Our Ref: FP/45/26/NMA

**Section 96A of the Town & Country Planning Act 1990 (as amended)
Town and Country Planning (Development Management Procedure) (England) Order 2015
(as amended) - Article 10**

Non material amendment following the grant of FP/137/25/HH relating to removal of dummy roof pitch, alterations to internal layout to include garage storage area and door, changes to doors and windows.

13 Bereweke Road Felpham PO22 7EG

Proposed Sections

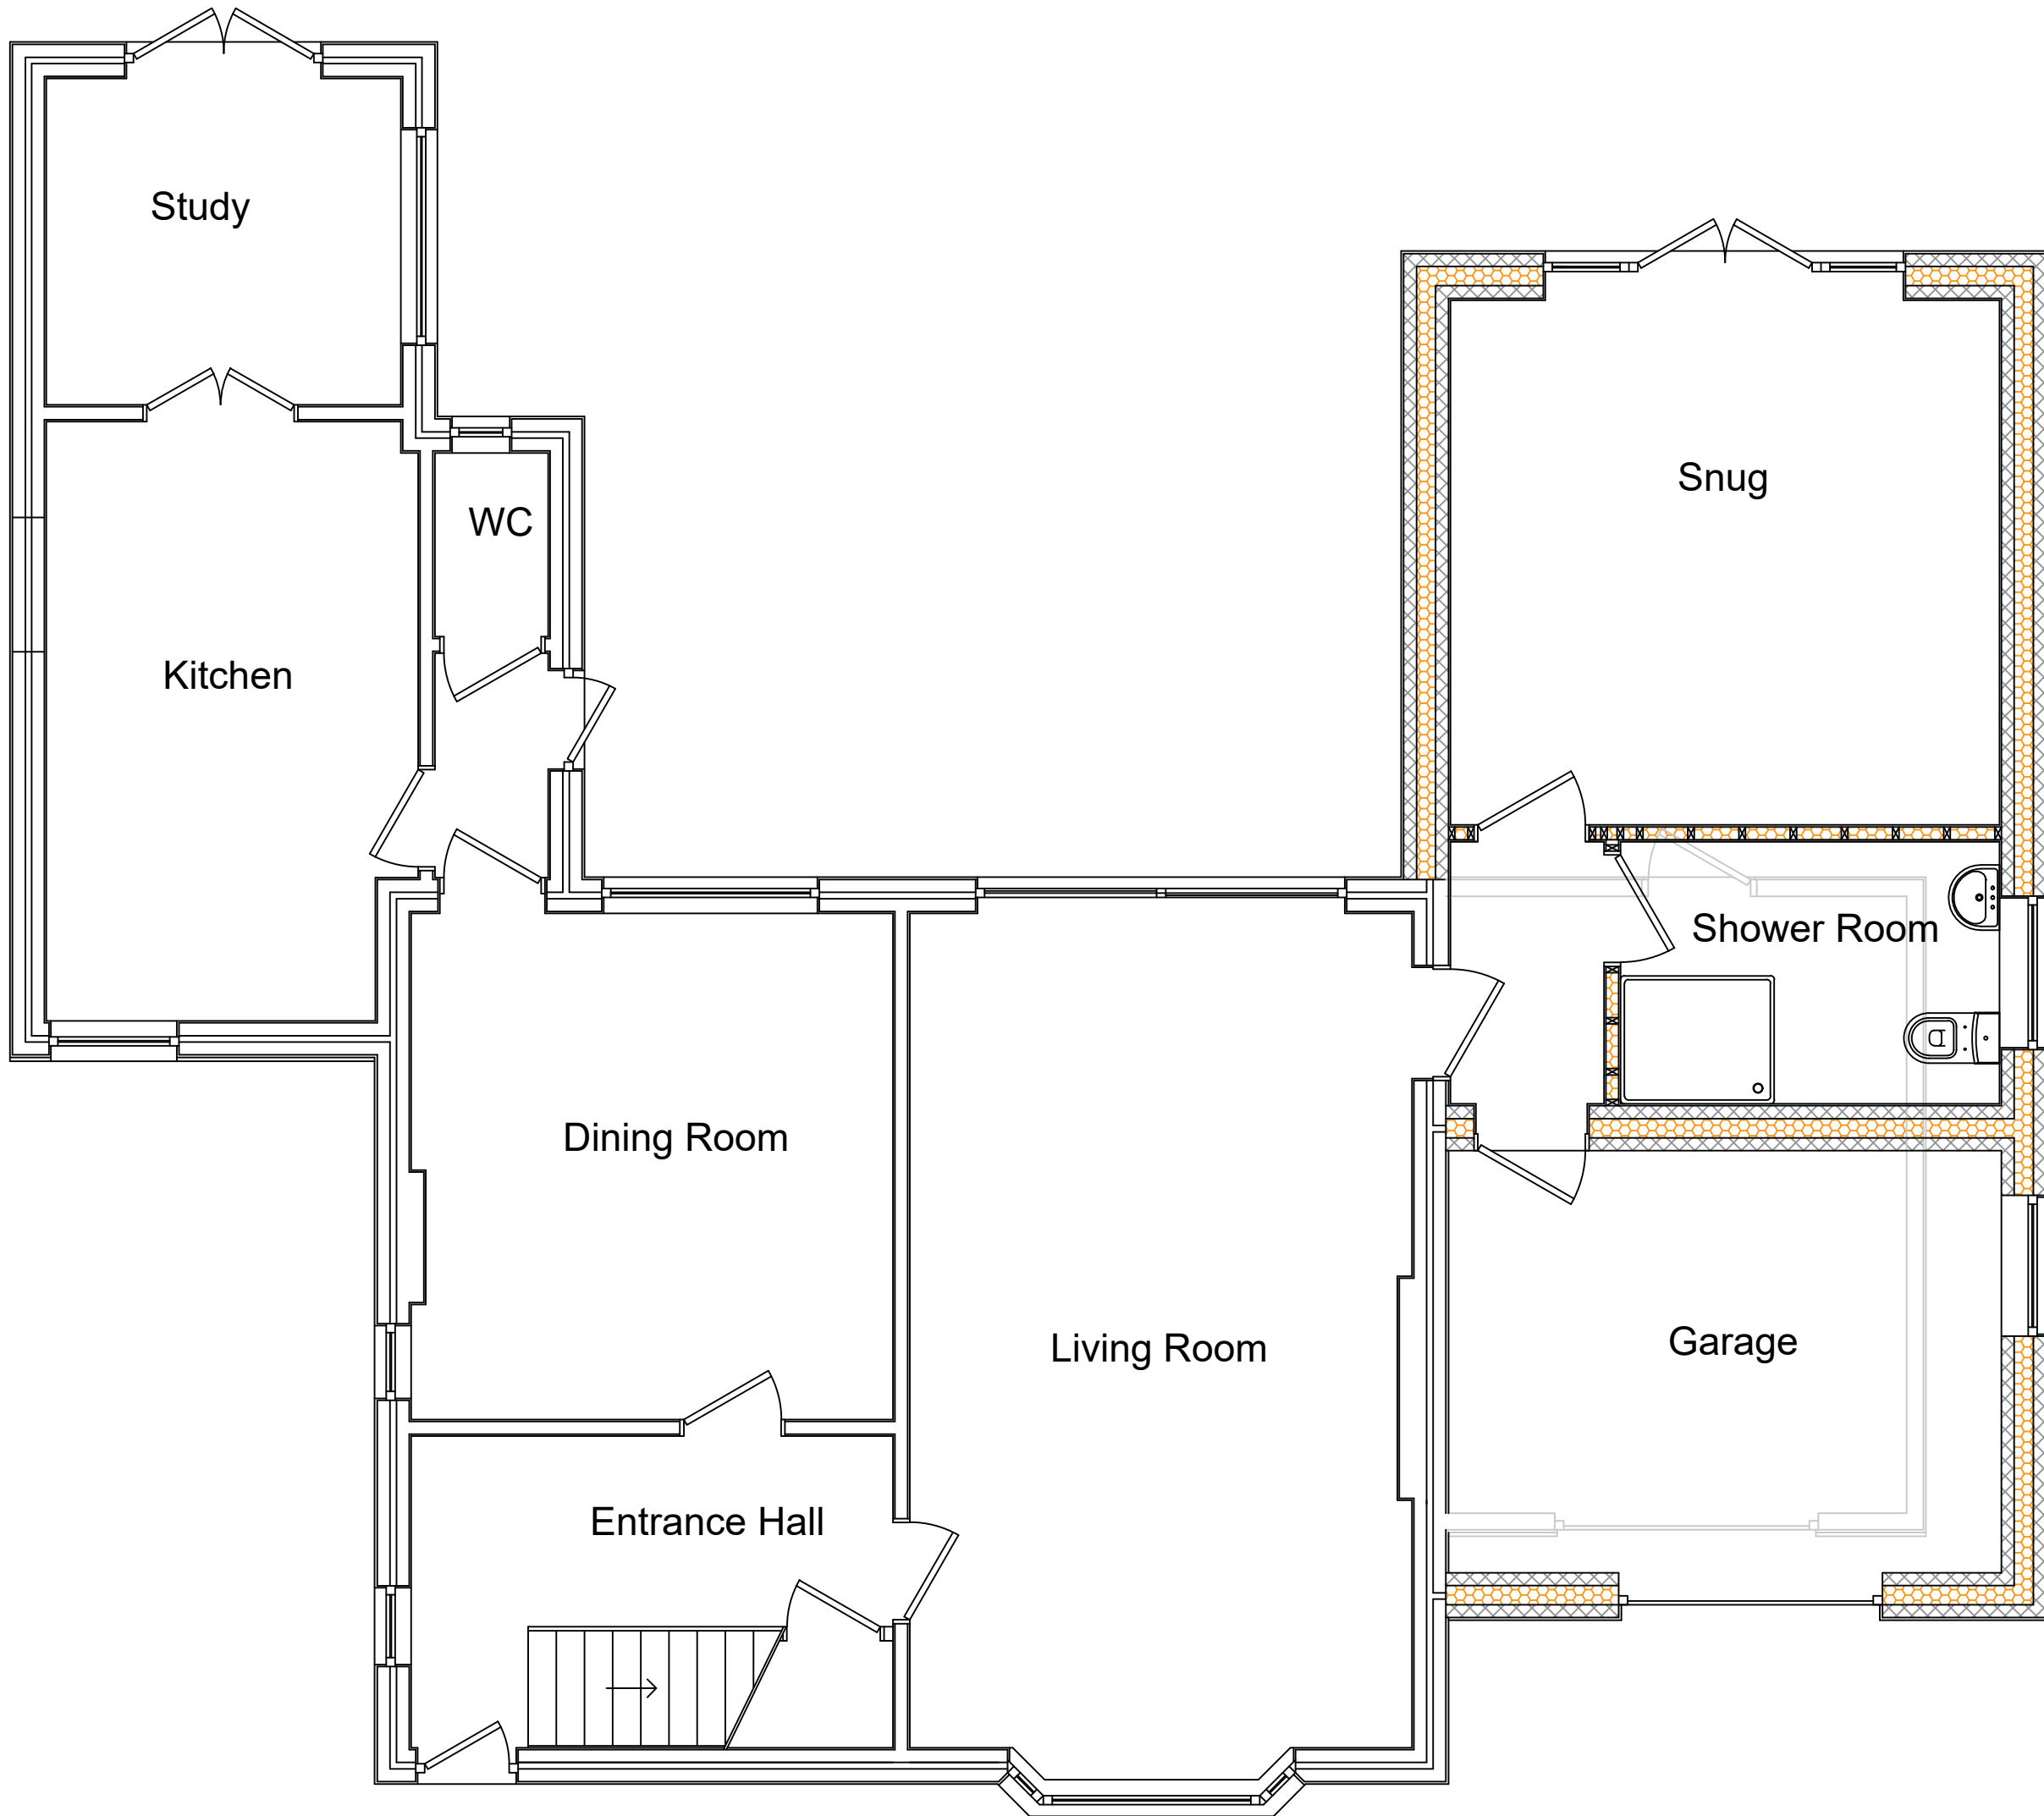
The proposal has been accepted as a Non-Material Amendment because it would reduce the maximum depth and width of the side single storey extension of the development and would not increase overlooking of neighbouring properties and it can therefore be considered under Section 96A of the Town and Country Planning Act 1990.

The proposal seeks to substitute the approved render and tiles with Marley Eternit cladding in Silver Grey C51 and to cover the mono-pitch roof with Ethylene Propylene Diene Monomer in black, with white soffits and fascia. The cladding would be in keeping with the colour palette of the host dwelling's existing render and would reflect the appearance of neighbouring properties which feature cladding in similar tones and colours. The changes are therefore considered to be minor in nature and can be determined as an NMA under section 96A of the Town and Country Planning Act 1990.

The following plans are now omitted from Condition 2:

- Proposed Ground Floor Plan 02.
- Proposed Elevations 05.

and replaced with the following amended plan:

- Proposed Plans and Elevation dated 07/04/26.
